From: Laura Gibbons
Sent: 05 April 2018 10:47
To: Planning.Responses
Subject: RE: Planning Consultation on BN/11/18/DOC

APPLICATION **BN/11/18/DOC**
NO:

Registered: 14-MAR-18
Site Address: Grove House, Highground Lane, Bournemouth, PO22 0PT

Approval of details reserved by conditions imposed on planning permission BN/36/17/HH relating to condition no.4 - Drainage

**Drawing Number: 2016/32/04**

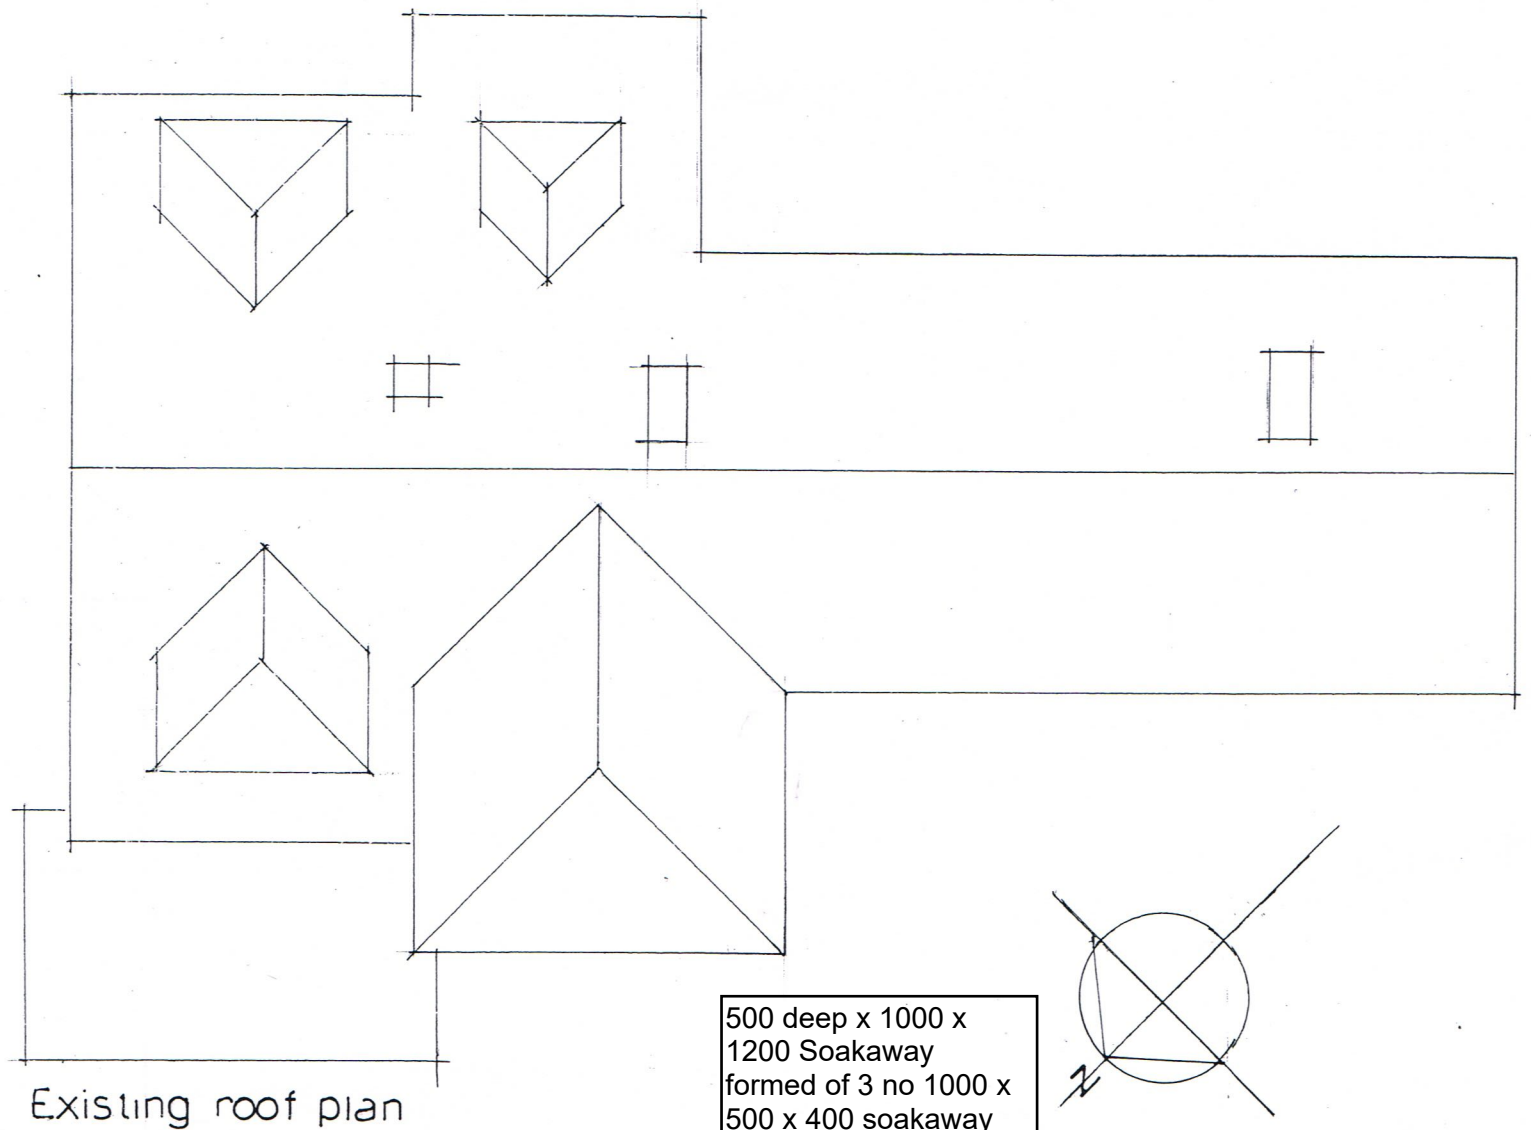
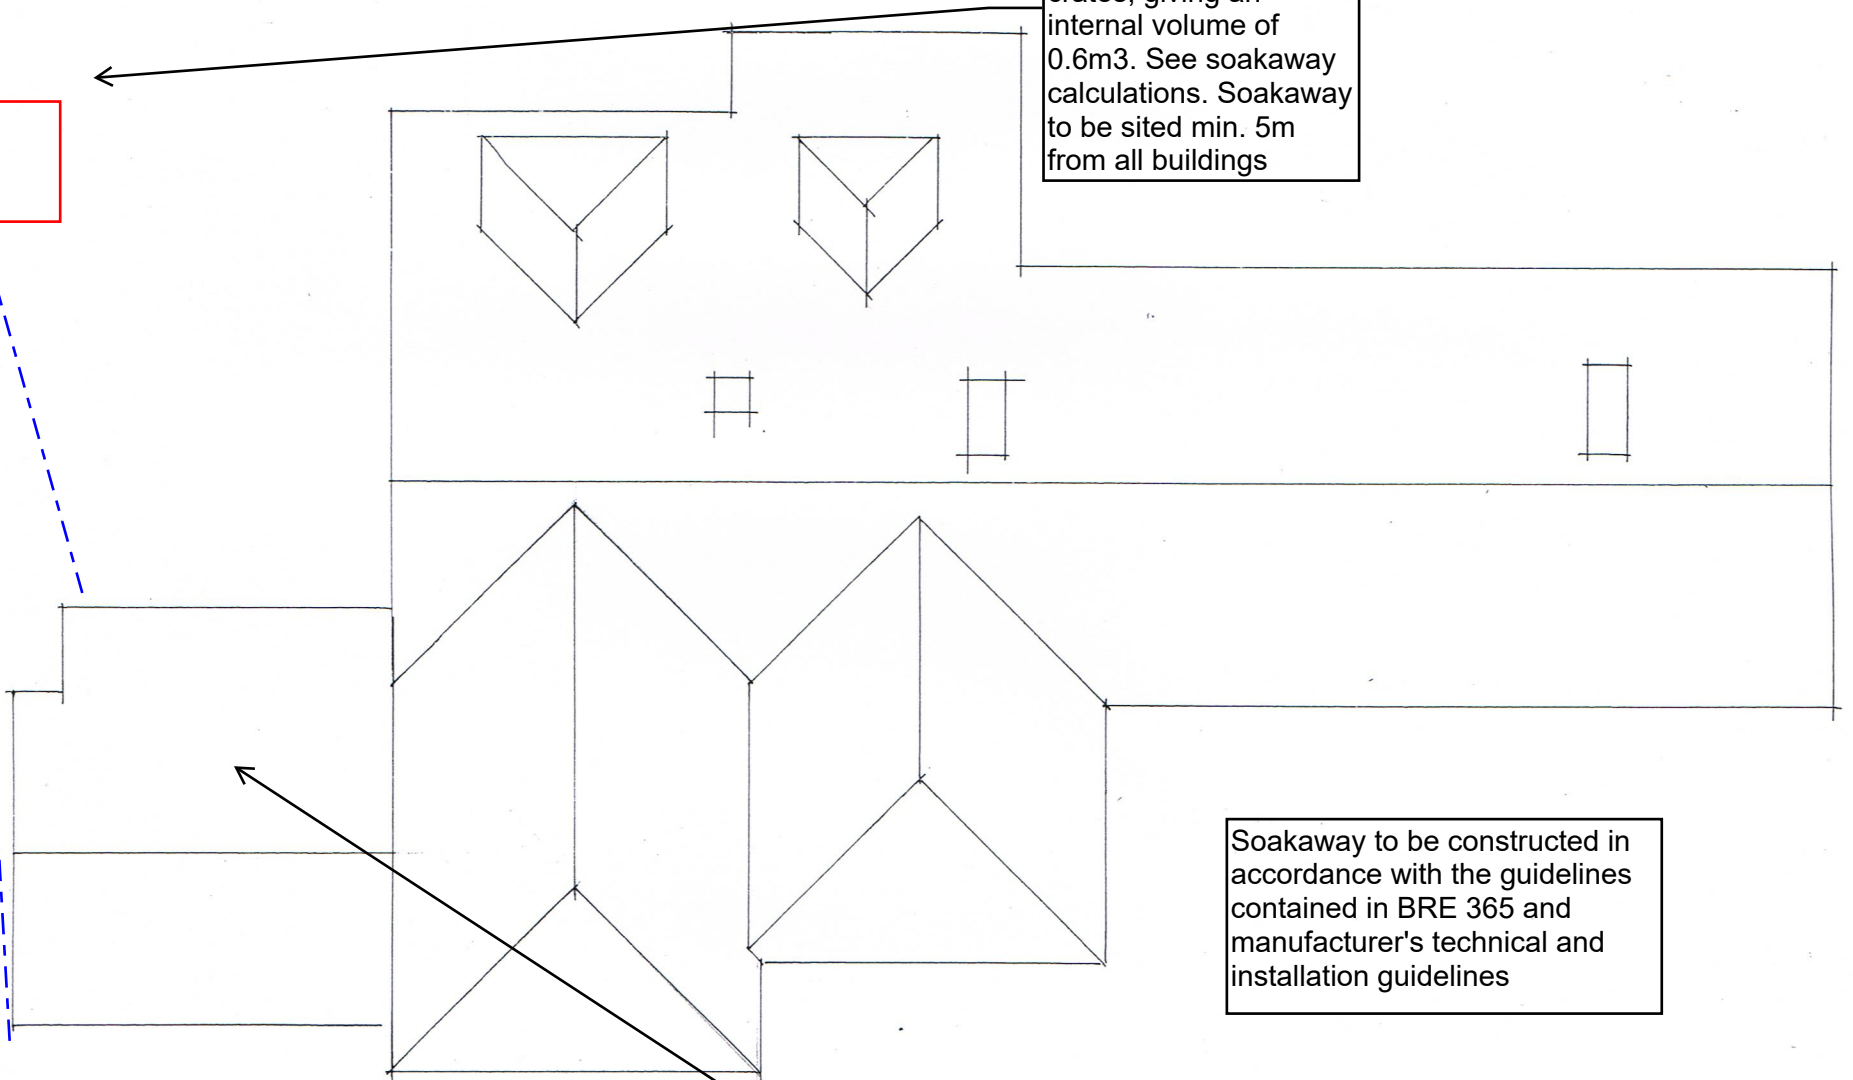
- Please provide confirmation of when the soakaway tests were completed and results of winter groundwater monitoring.
- Soakaway design needs to accommodate the 100 year +30% climate change event. The current calculations for the 10 year storm +10% climate change are insufficient.
- Silt traps are required upstream of the soakaway.
- Construction details of the soakaway and silt traps are required.
